THE A47 NORTH TUDDENHAM TO EASTON DEVELOPMENT CONSENT ORDER

CLOSING SUBMISSIONS ON BEHALF OF THE [REDACTED]

# PROPOSED WOOD LANE JUNCTION

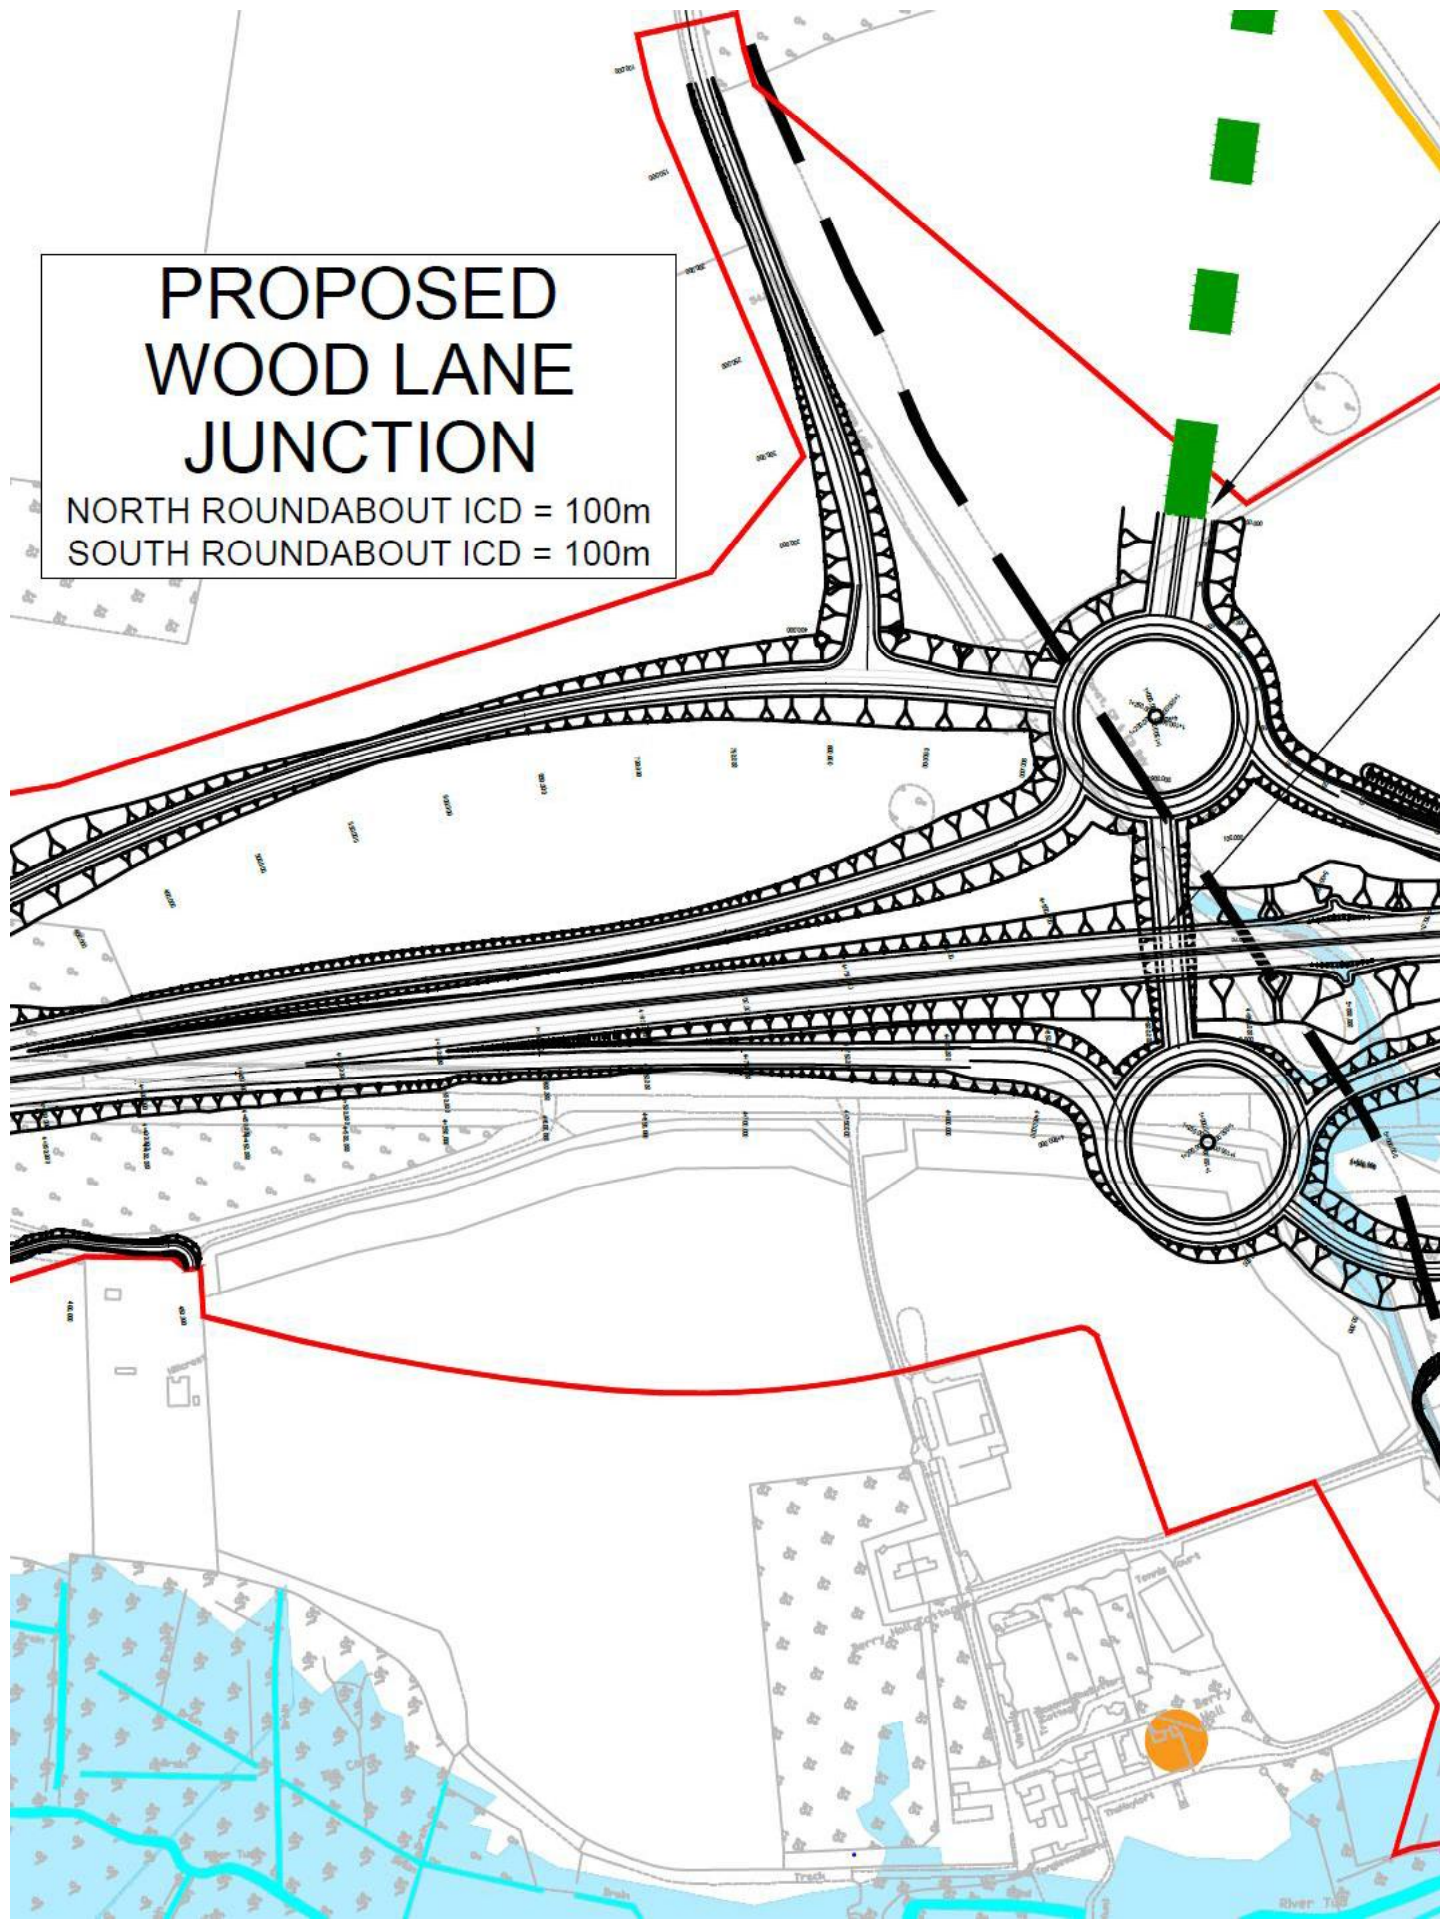
31. **Item 5 (ii) - form** – The Owner still maintains that the junction has been oversized for the predicted traffic levels for all the reasons given in the Transport submissions mentioned at (i); that if it were genuinely needed to cater for a large traffic flow a two bridge roundabout would have taken less room than the two currently sized dumbbells; and that if the dumbbell solution was followed the dumbbells if designed more thoroughly could have achieved less land-take.

35. **Item 5 (iii) need for the size chosen in view of NWL uncertainty** There appears to be agreement between the parties that the junction can be reduced in size without NWL, but not on how much. With NWL the Owner asserts that it has been overdesigned and can still be reduced but the Applicant believes not. The question was asked by the Ex A IN ExQ3 at Q14.3.2.

Figure 2-3: Wood Lane Junction Alternative 1

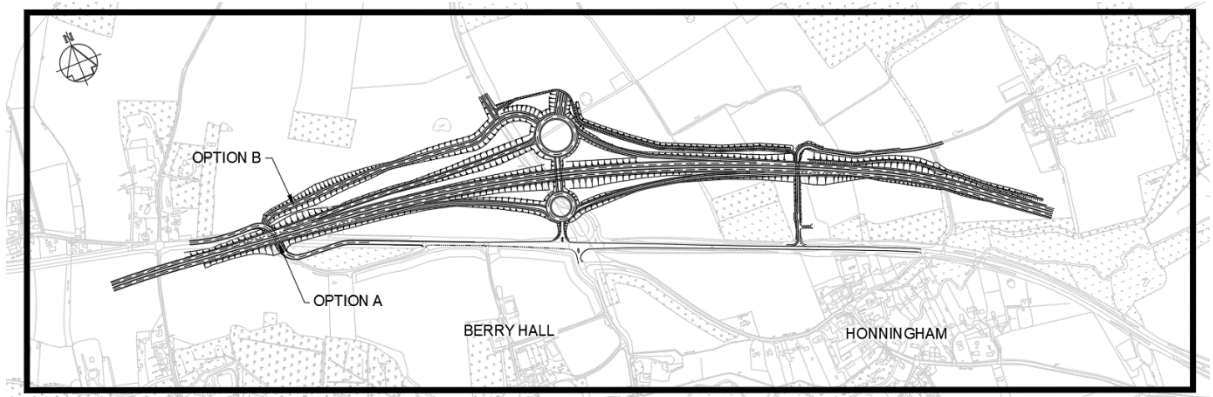
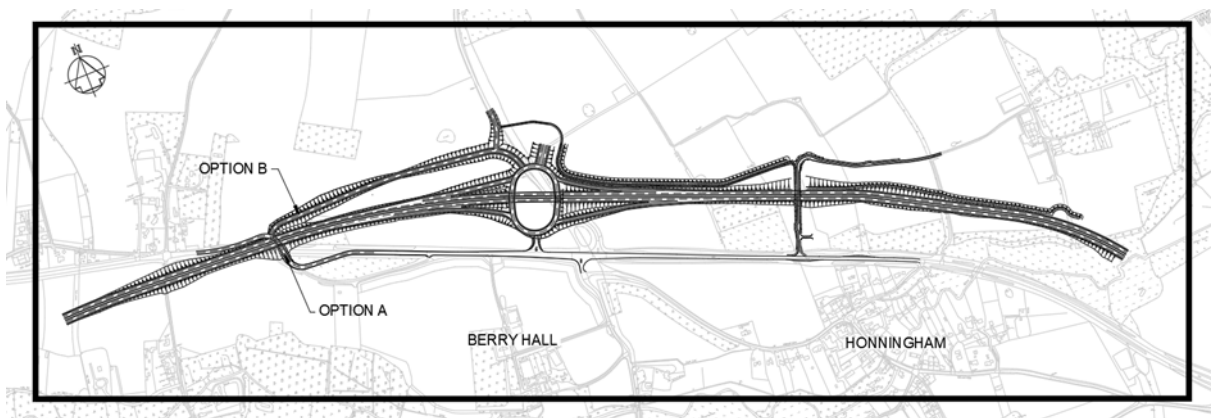
While spending much work in criticising matters of detail in the Owner's suggestions for alternatives (see REP6-016 in particular), some aspects of which were incorrectly interpreted, at no point has the Applicant worked on making any suggestion themselves since the DCO on any aspect of the junction design save (for which the Owner is grateful) in relation to the drainage route by Berry's Lane and, recently to consider some redesign of to the cycleway.

20. **Sub-item iv – the period after the DCO application.** It remains the Owner’s view and that of his Transport consultants that the alternatives proposed at REP3-045 would be feasible despite the Applicant’s views in its Revised Appraisal at REP6-016 (see most recently REP7-020 and REP7-037). The Applicant’s objections as to additional land take failed to take account of the land that could have been returned to the owners north of the existing A47, particularly that on the east side of the junction. Norfolk County Council’s reply did not address the benefits which would result (listed in REP3-045), perhaps influenced by its partial position as promoter of the NWL.
